From: Sue Howell
Sent: 08 August 2019 17:17
To: Planning.Responses <Planning.Responses@arun.gov.uk>
Cc: Raymond Cole <Raymond.Cole@arun.gov.uk>
Subject: RE: Planning Consultation on: WA/48/19/RES

Comment from Greenspace

APPLICATION **WA/48/19/RES**

Site Address: Land to the East of Fontwell Avenue Fontwell Avenue Fontwell

Drawing Title
Planning Layout

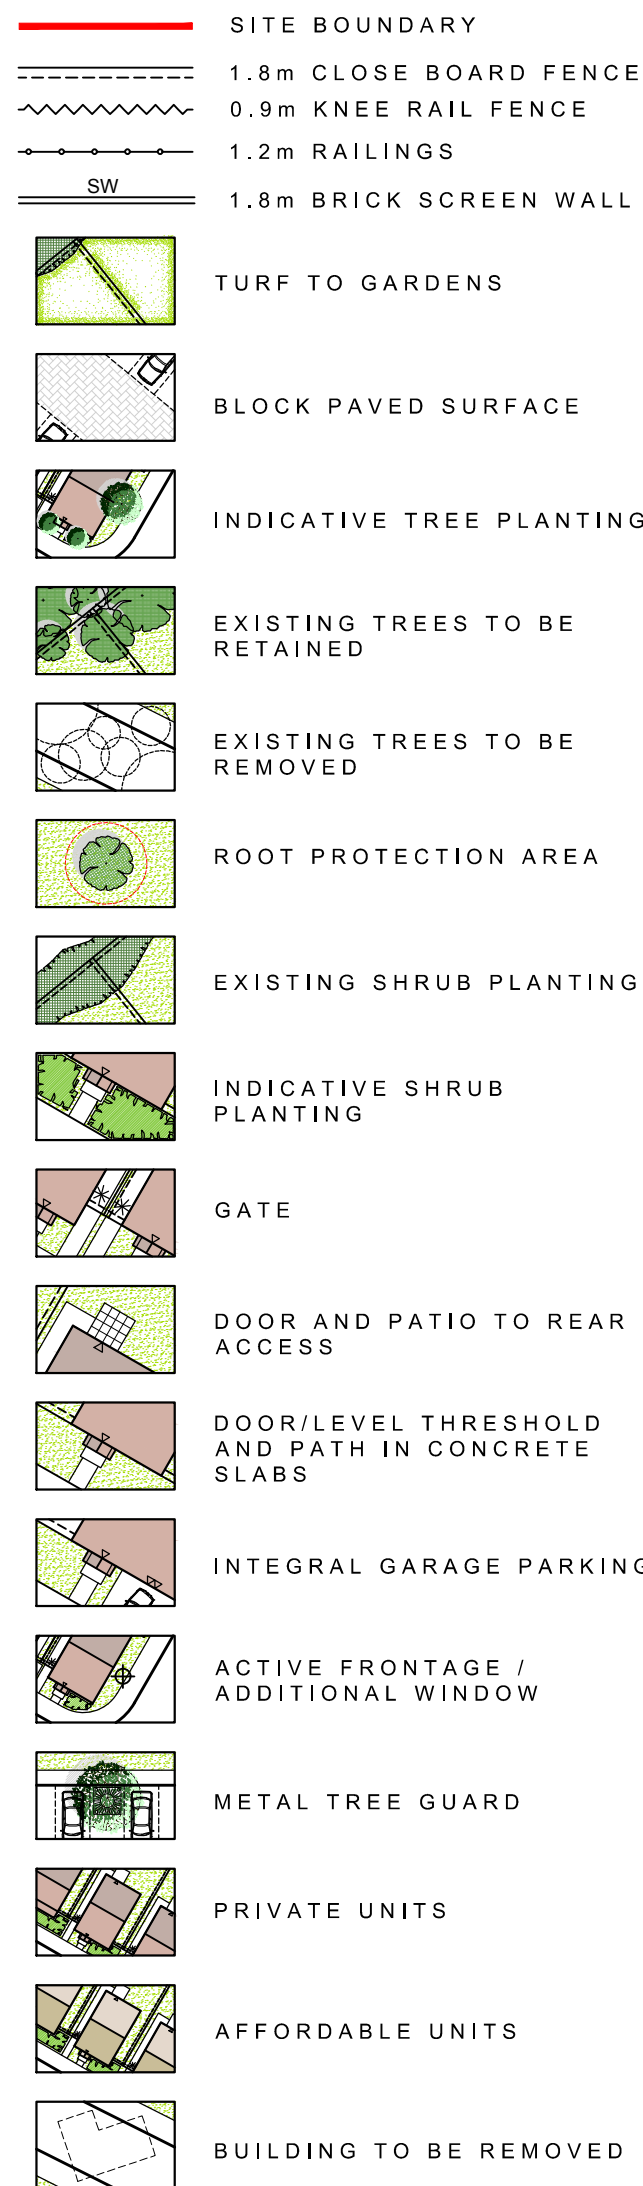
The majority of the areas of Public Open Space appear to have been decided in consultation with the Parish Council, who have clearly worked to achieve their ambitions for this site. In general Arun DC are supportive of what is shown with a large usable central area of Public Open Space with connecting pathways both across to the road networks beyond, the houses and the play and recreation facilities.

The siting of the community building does not have a direct correlation with the POS areas and the allocated parking could prove problematic if large groups of external users choose to use this facility.

The LEAP and MUGA appear to be well equipped and suitable for location and I'm sure will attract good use. It is difficult to see from the scale of the plans if the addition of LAPs have been included into the area of POS within the site. Whilst LAPs are unequipped areas of natural play often only including natural element such as land forms, boulders, large logs, seats and bins they do offer valuable play opportunity throughout developments and should be considered re location when the landscape detail is produced.
